AW-85-18-HH – 10-5-2018 –OBJECTION

Head of Planning Services
Arun District Council
Maltravers Road
Littlehampton
BN17 5LF

OBJECTION TO – AW/85/18/HH, 54 Kingsway – PROPOSALS TO EXTEND HOUSE WITHIN THE SETTING OF CRAIGWEIL HOUSE CONSERVATION AREA.

DRAWING:
Existing Elevations

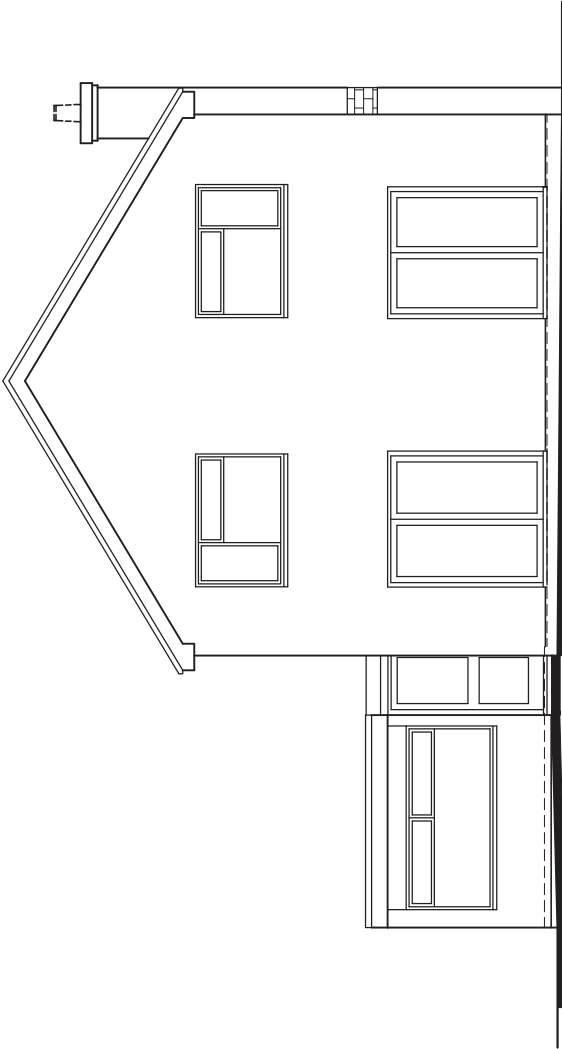
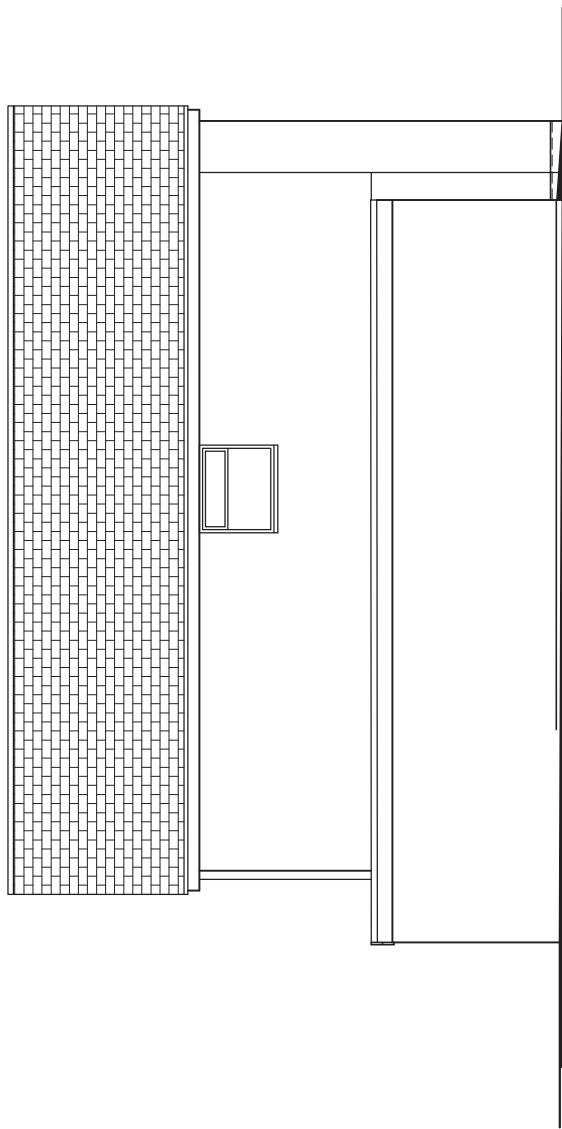
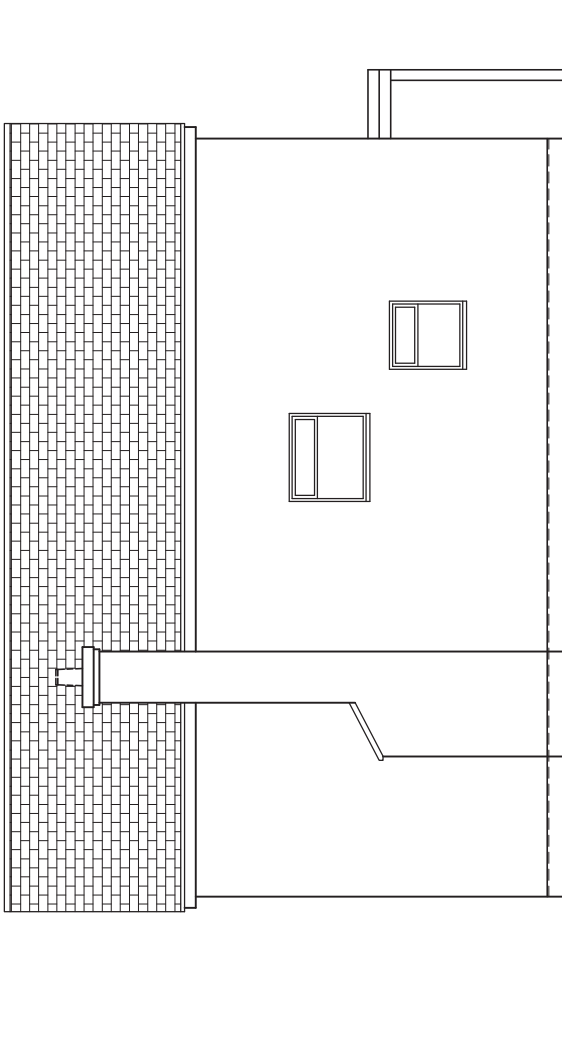
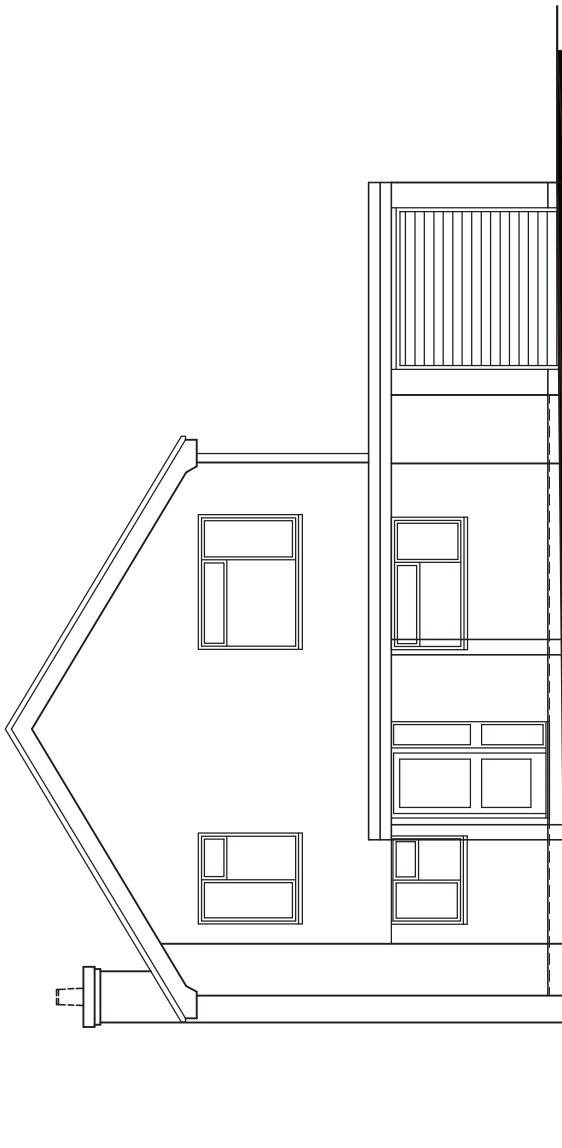
- *That no harmful impact will be caused to the roofscape of the conservation area. The roof height is increased and places the property out of kilter and not subordinate to No. 52 Kingsway, which we find unacceptable.*

- *The RETENTION of SPACES BETWEEN PROPERTIES, and other open areas which contribute to the character or appearance of the area. To destroy the single storey garage and then INFILL BUILD to well above existing roof level is to fly in the face of one of the major design concepts of Auty and Du Cros which was to create the estate with, in Kingsway, in particular, wide vegetated, treed verges and houses well set back ‘with spacing between them both at ground level and first floor levels providing a sense of spaciousness’. The infill proposal is an insult to the design concept; ignores and defies the constraints of the CA Statement, SPG, and English Heritage letter. The requirement of space between houses at first floor level has been respected and now the owners of an indifferent 40 year old house, not even in the area but in its setting, must not be allowed to destroy this 84 year old character feature – it simply must be Refused. Repeatedly such applications at Craigweil have been refused by the LPA. It would be a travesty if this was allowed in its setting. The High Court held that ‘preserve’ means ‘not to harm’ – and they must not.*

'The extension does not have an adverse overshadowing, overlooking or overbearing effect on neighbouring properties'. **This outrageous attempt to push this house as far as possible into No. 52 Kingsway shows no consideration whatever for that owner and is built hard up to the boundary, as is the existing garage. And it achieves the dubious distinction of conflicting with each one of the provisions and constraints of e DEV19, while showing no sympathy to established character or style. Nor can it ever do this for the basic utility construction allows no such opportunity. It is 1978.**

It damagingly overshadows – no, it completely blocks the eastern side of No. 52 until the occupant can only just open her windows - and we say that is not architecture, nor acceptable – it is disgraceful. From any viewpoint, the proposed house totally overlooks and is completely overbearing – even in the front garden and back garden. It is an indictment upon the applicant and the architectural profession - in CHECAA's opinion – and especially so in a conservation area – that such gross disrespect is shown to the next door neighbour; the environment or the character or appearance of Craigweil House CA. It neither preserves nor enhances anything!
